**PETITION #95-14 (C)
C.D. SITE PLAN**

SUBJECT: Administrative Approval for Petition No. 1995-014C Wilkinson Property

CONDITIONAL REZONING REQUEST
C.D. SITE PLAN

JOHNNY WILKINSON PROPERTY
PERFORMANCE ROAD - MECKLENBURG COUNTY, N.C.

CONDITIONAL REZONING REQUEST
 C. D. SITE PLAN
 JOHNNY WILKINSON PROPERTY
 PERFORMANCE ROAD MECKLENBURG COUNTY, NC

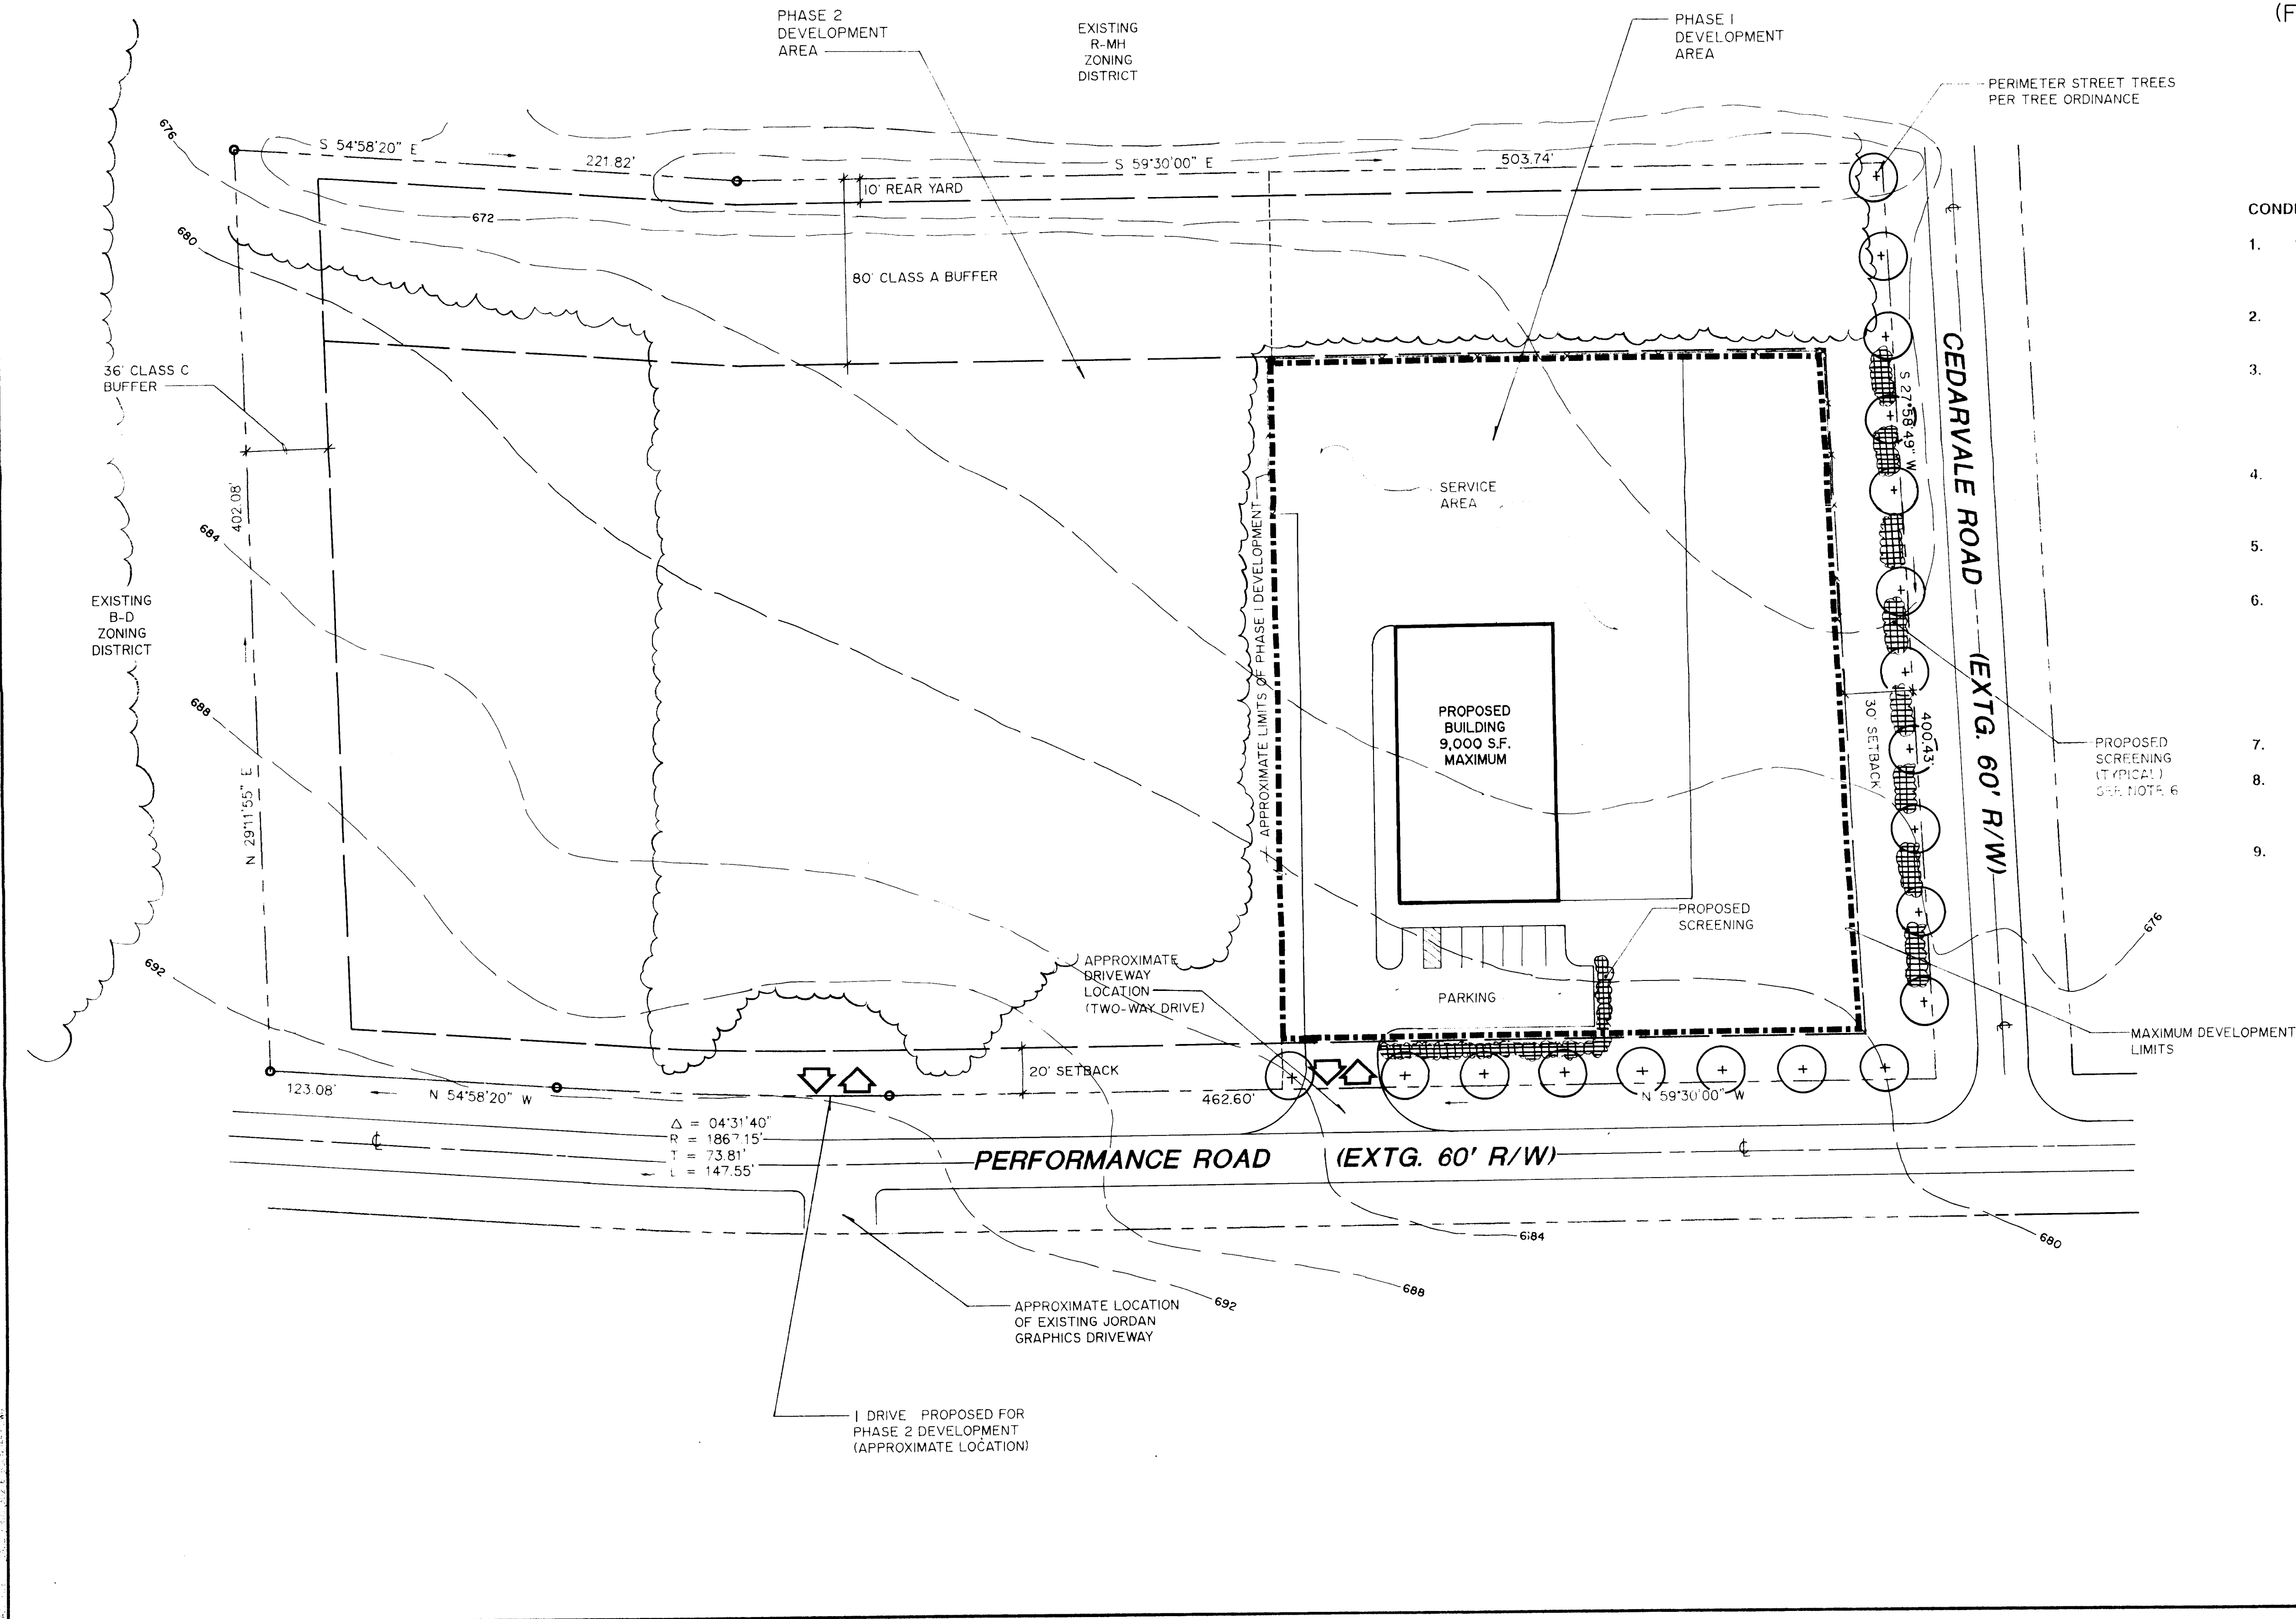
Attached is a revised site plan for the petition listed above. The site plan has been revised to show when a turn lane will be required to be built for the development. Since this change is minor and does not alter the intent of the development and meets the requirements of the Charlotte Zoning Ordinance Section 6.207 Alterations to Approval, minor changes, I am administratively approving these plans. Please use these plans when evaluating requests for building permits and certificates of occupancy.

- A new traffic impact analysis did not warrant the turn lane at this time for the proposed 6,000 square foot use.

4. A LEFT HAND TURN LANE AT DRIVEWAY ENTRANCES SHALL BE REQUIRED WHEN 47,001 SF OF BUILDING AREA HAS BEEN CONSTRUCTED ON THE SITE.
5. THE CLASS A BUFFER SEPARATING THE SITE FROM THE ADJOINING R-MH ZONED PROPERTY SHALL BE LEFT UNDISTURBED.
